REF: 20/03660/REM

Location: Stone Pits Hempton Road Deddington OX15 0QH

11 June 2021

LANDSCAPE MASTERPLAN
HARD AND SOFT LANDSCAPE

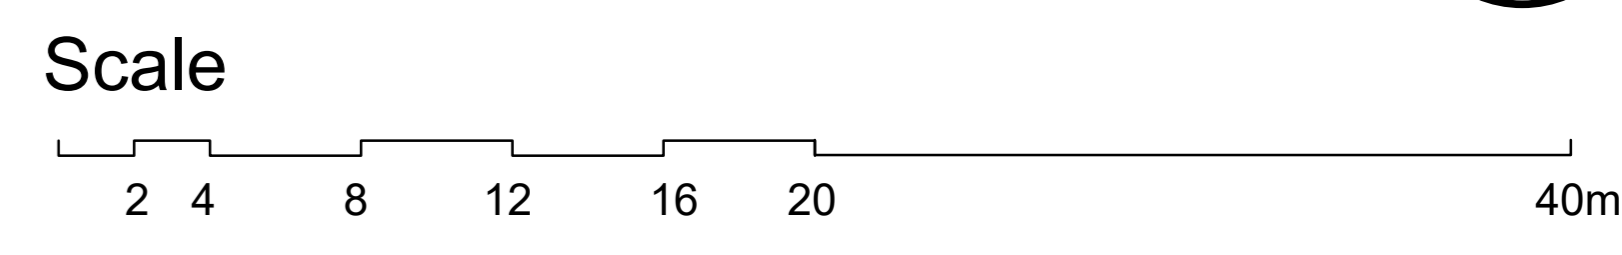
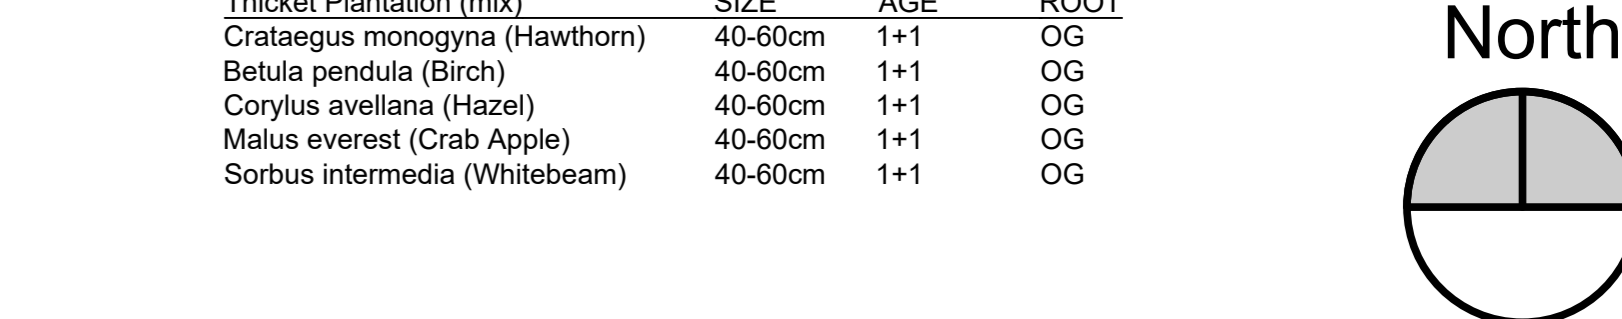
The pedestrian link to the north of the development creates an excessive level of permeability. It introduces a level of anonymity associated with its public use and should be pushed away from the private areas of the development. Whilst clear and direct routes are important they should not undermine the defensible space of neighbourhoods.

Further clarification is required with regards to its intended use, necessity and position.
